CITY OF ALBUQUERQUE

**Planning Department
Transportation Development Services Section**

April 20, 2012

Re: Certification for Permanent Certificate of Occupancy (**C.O.**)
High Desert Dental, [G-16/D146]
3520 Montgomery Blvd.
Architect's Stamp Dated 04/11/12

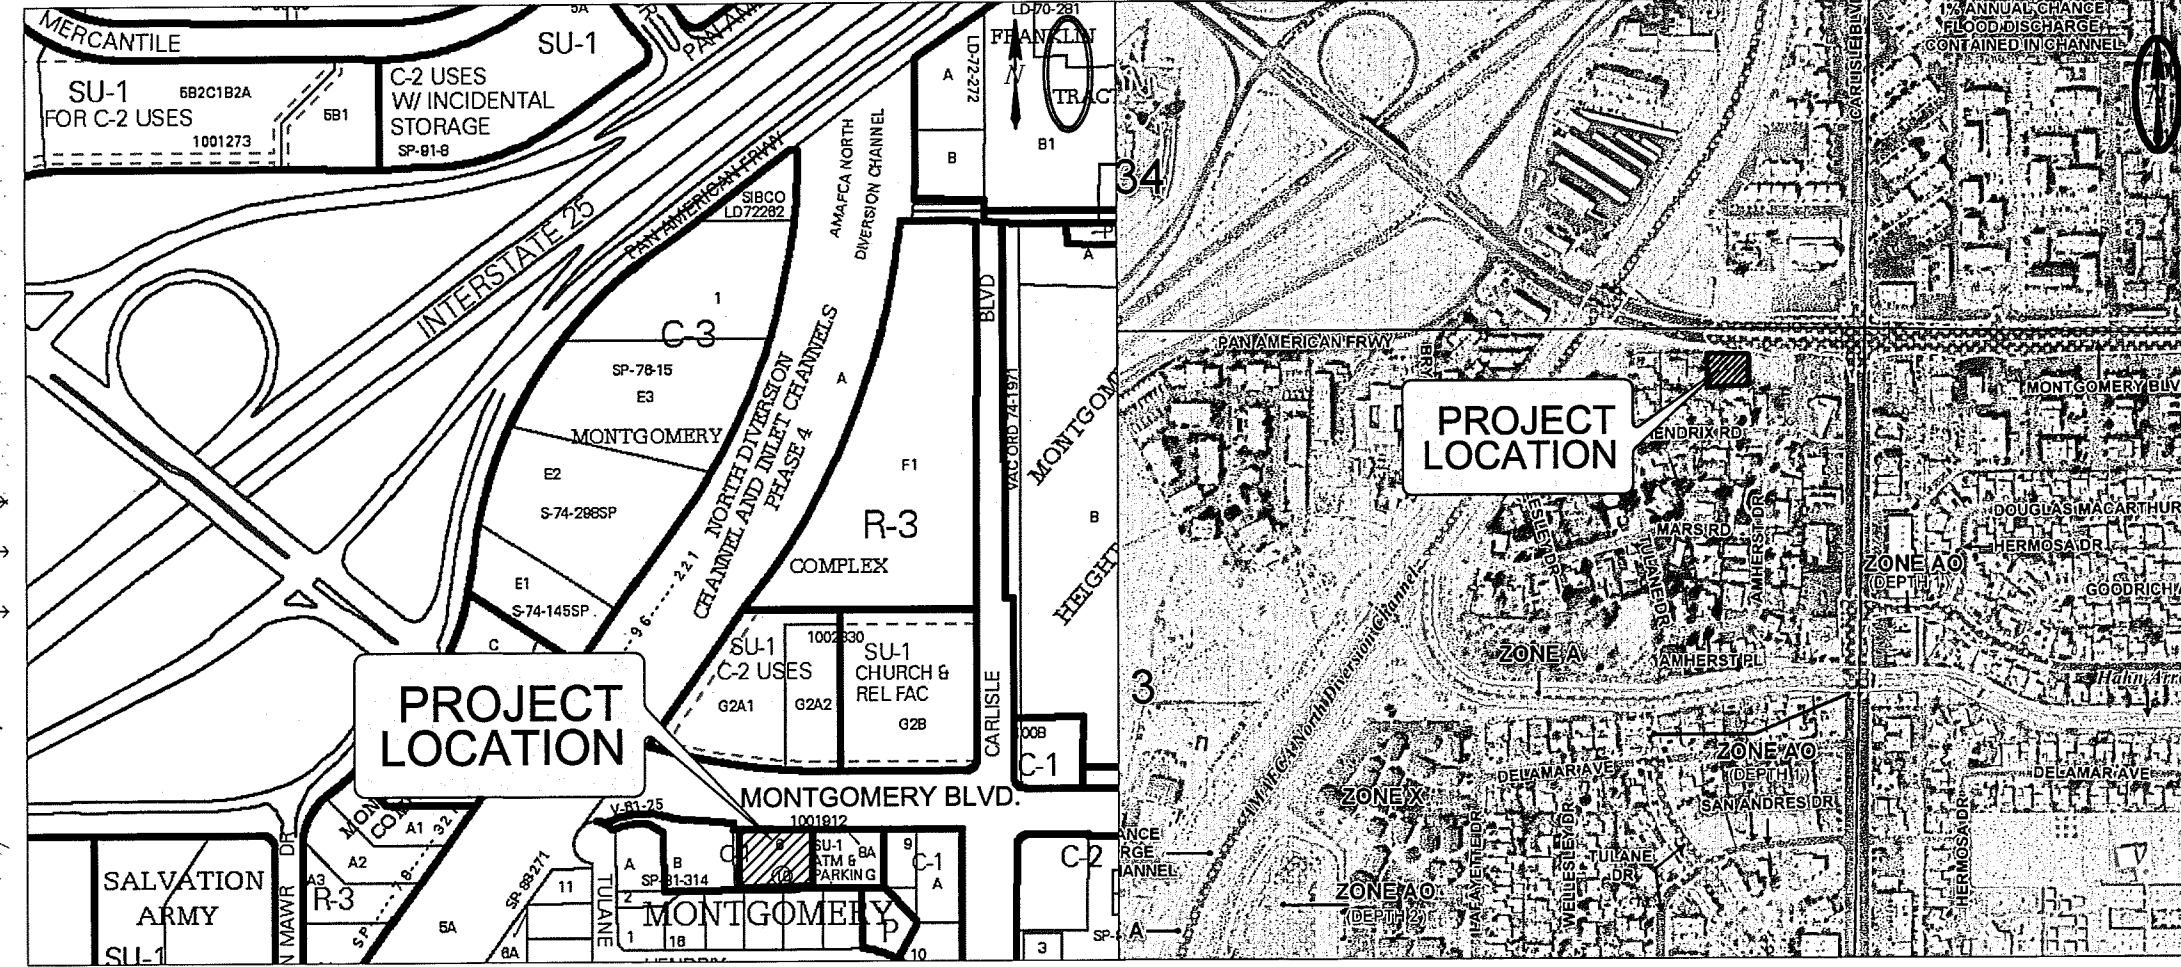
One comment on the area between the new Retaining wall and the existing garden wall, please make sure that the soil slopes away from the garden wall to ensure that seepage from any precipitation does not occur on this wall.

Hydrology is requesting that all proposed landscape areas are depressed to retain/infiltrate the rain that falls on them.
